LAND USE PERMIT

NEILLS CREEK FARMS  
SECTION 7 QF PHASE II

**Request permit review and changes please.**

REVISION  
No 15567 5-8-06

No 15567

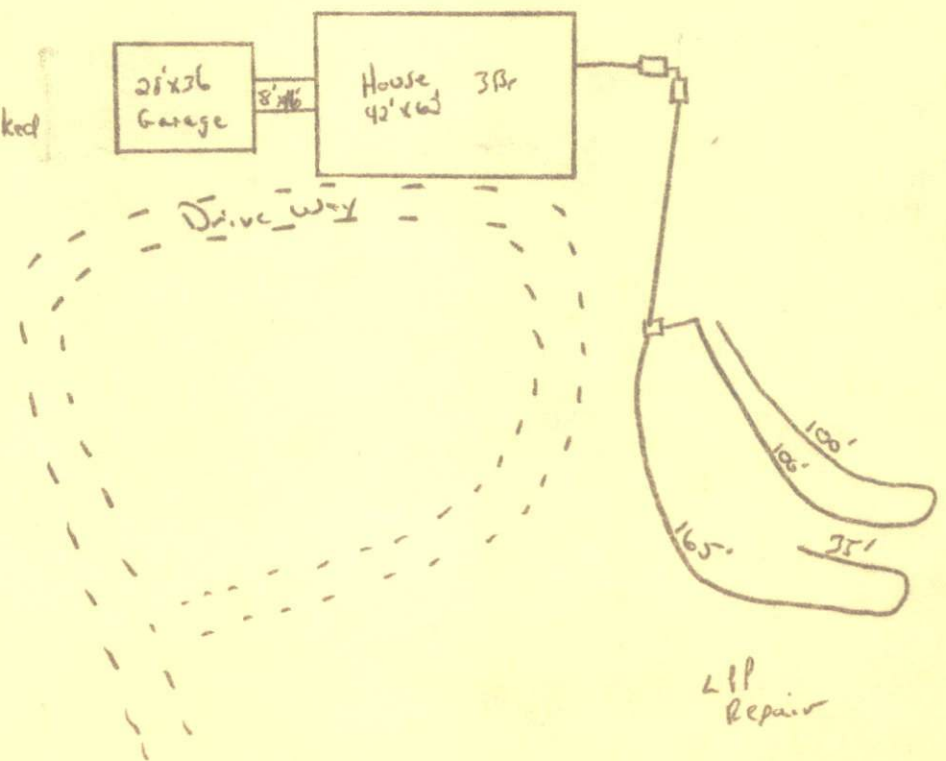
1. Change to a conventional system next to the front right corner of the house
2. Feed from Septic Tank to Distribution box would be best ran under the driveway – may I do so and use a better pipe, such as schedule 80 or double sleeve at this point – I can still divert around the edge of the driveway if this is recommended or necessary
3. Four 100 ft. lines would be easier to dig if acceptable, but the original configuration is fine if you see this is best, either way, the line layout needs to be flagged

Type of system:  Conventional  Other XXXXXX \*Red

Size of tank: Septic Tank: 1000 gallons Pump Tank: XXXX gallons \*Red

Type of System: Conventional OK - Red Other ~~XXXXXXXXXXXX~~ - Red

Tank Volume: Septic Tank 1000 gallons Pump Chamber ~~XXXX~~ - Red gallons

Number of fields 1 Number of Lines per Field 2 Length of lines 100 ft. - Blue  
200 ft.
